PLANNING APPLICATION No: 3/13/0243

Application: Proposed Garage

At: THE VINES, PRESTON ROAD, RIBCHESTER

NORTH ELEVATION
1:100

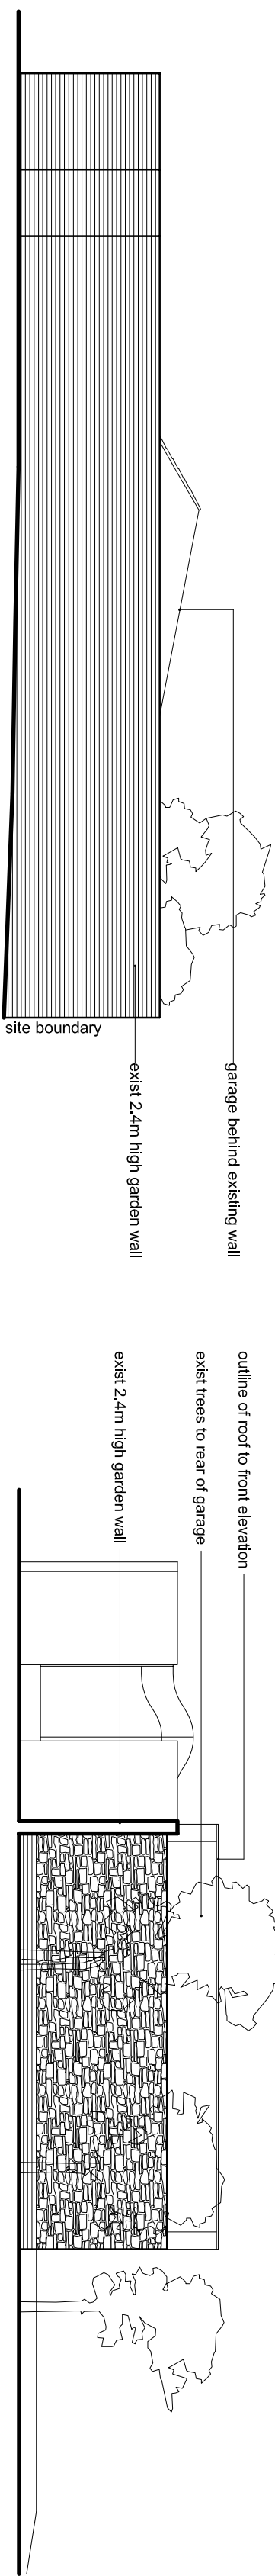
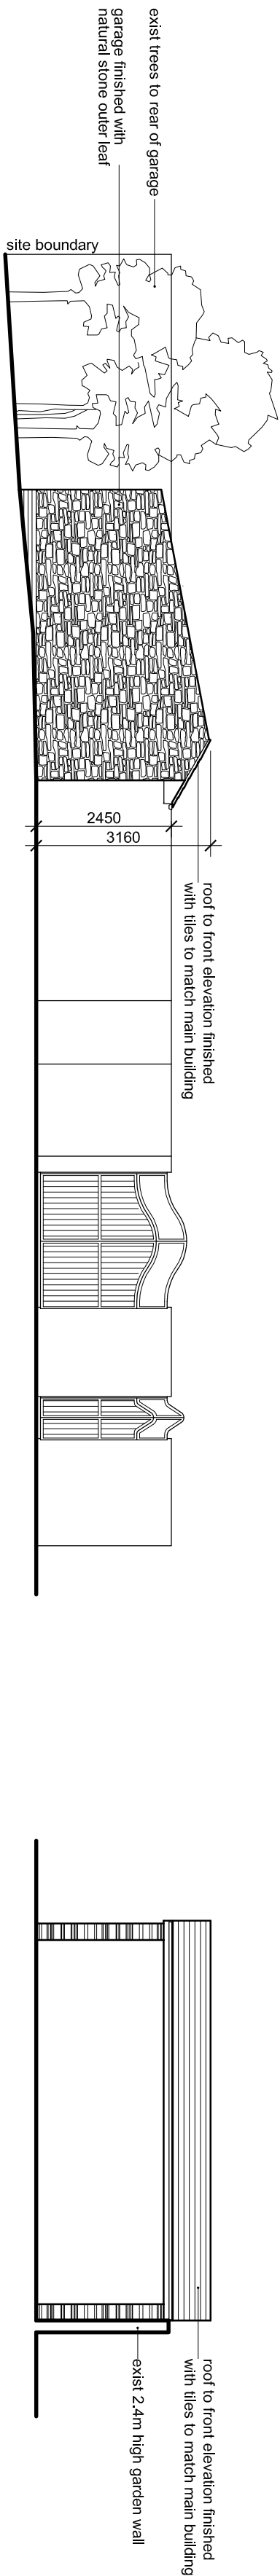
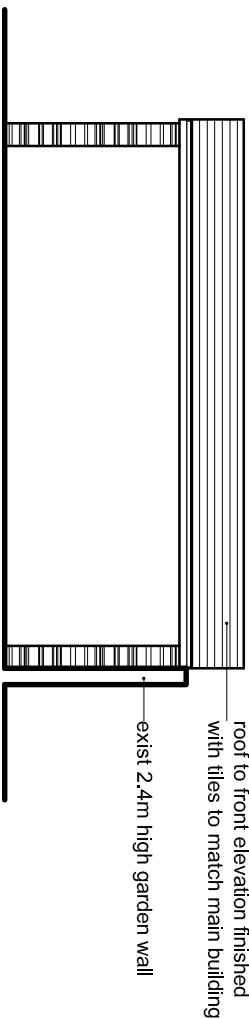
Secondly, while it can be said that much of the building is hidden from the highway the visible roofing is of a fairly shoddy appearance. The remainder of the building is of a stone effect construction when all the surrounding properties are built of brick.

SITE PLAN
1:200

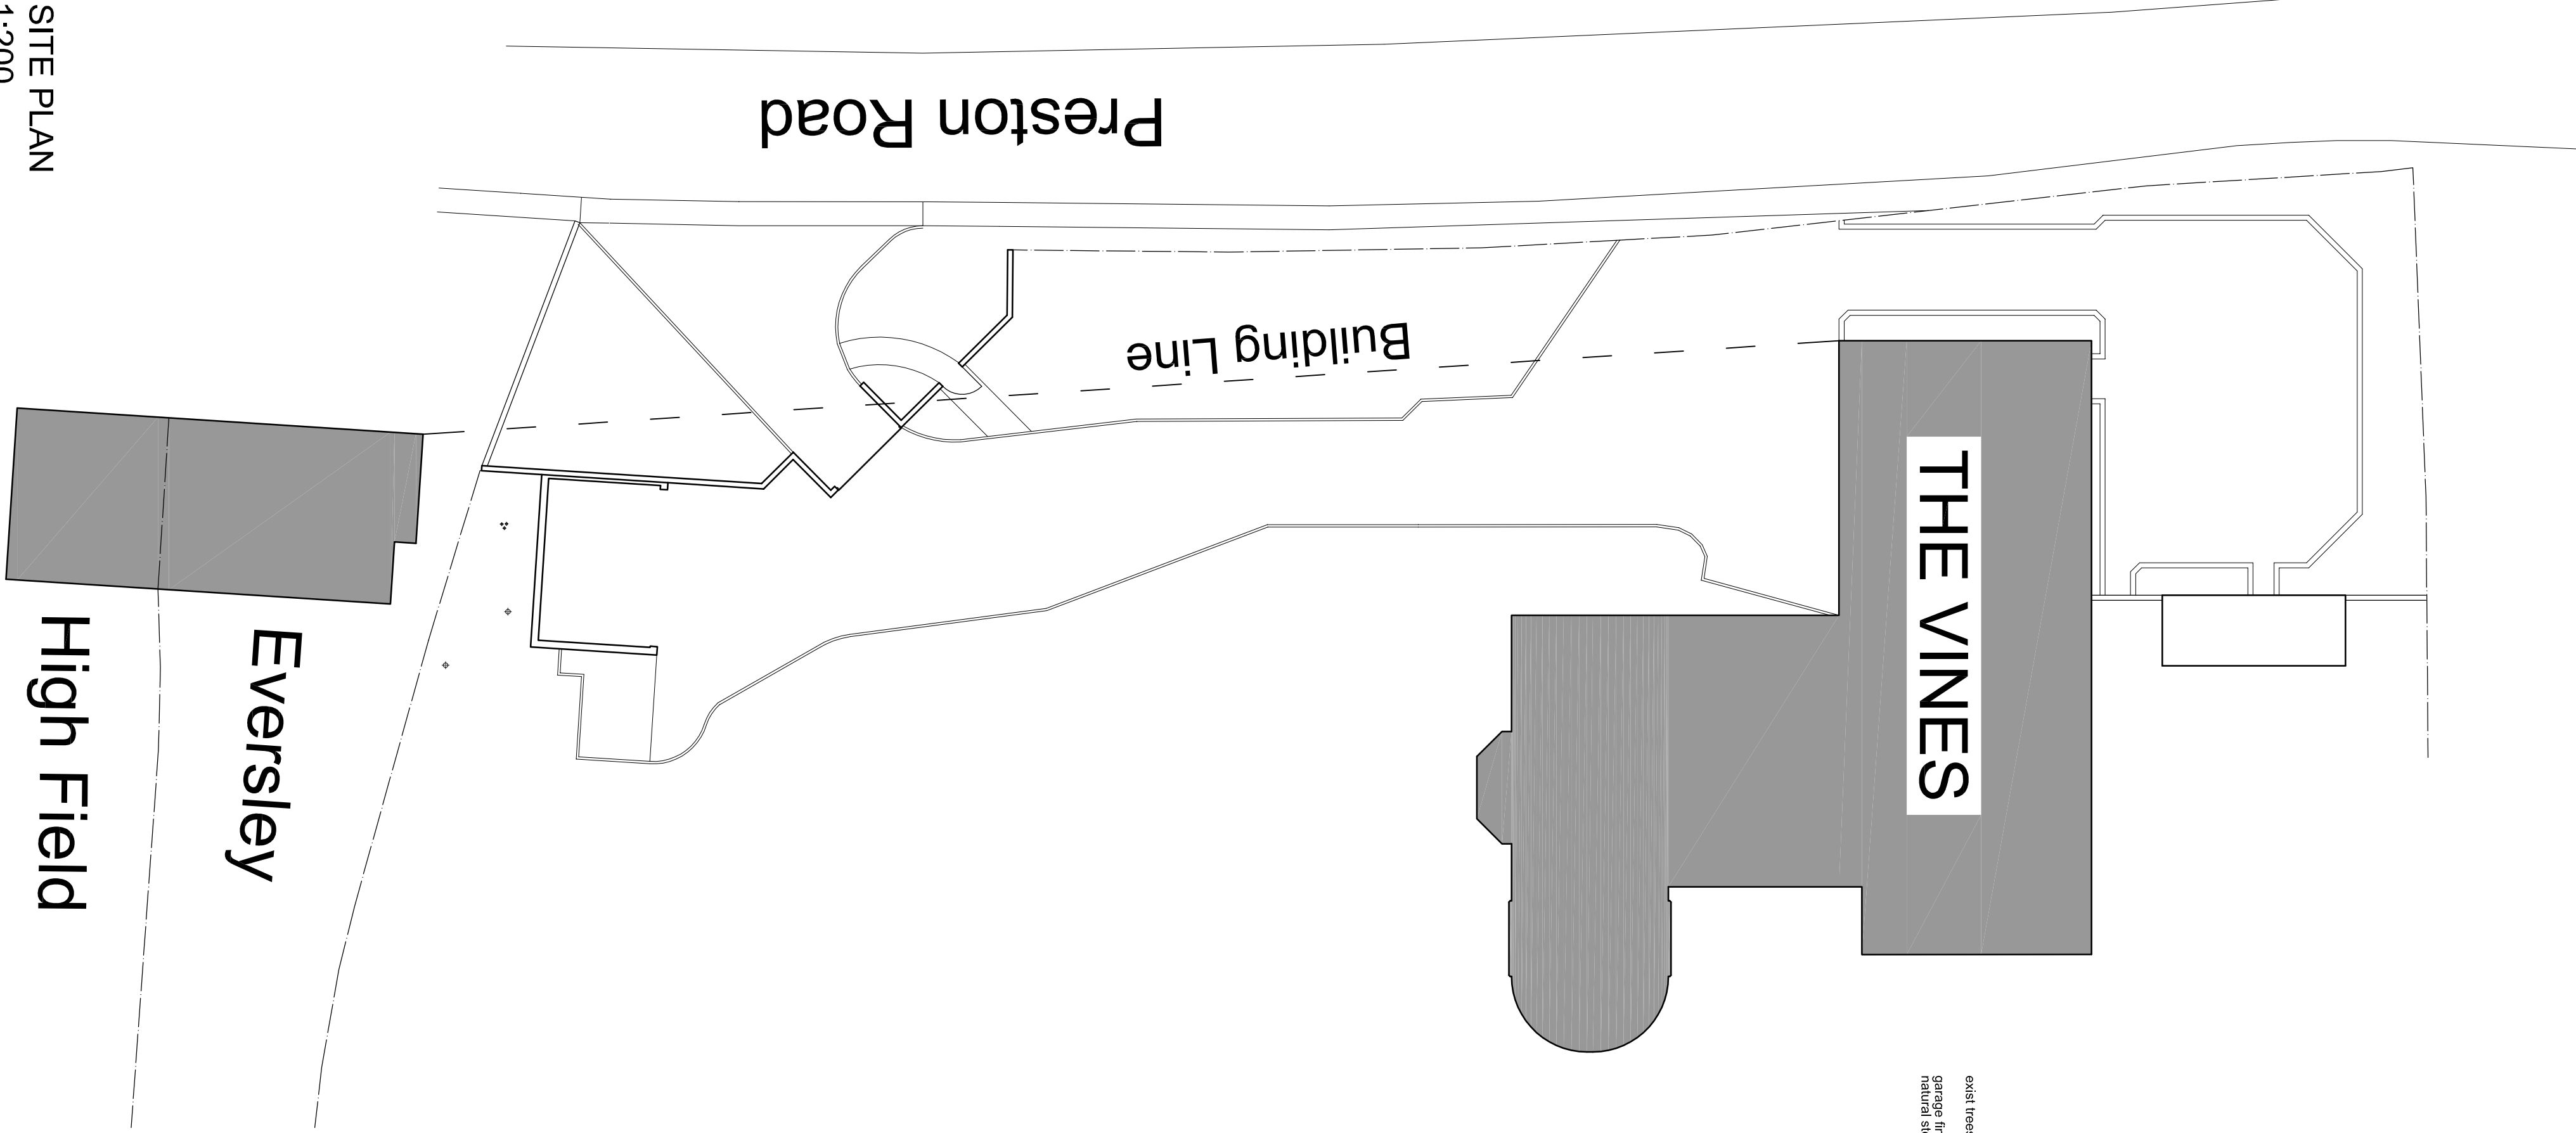
Firstly, despite the area of land available a site has been chosen close to the neighbouring property with possible adverse effect on it.
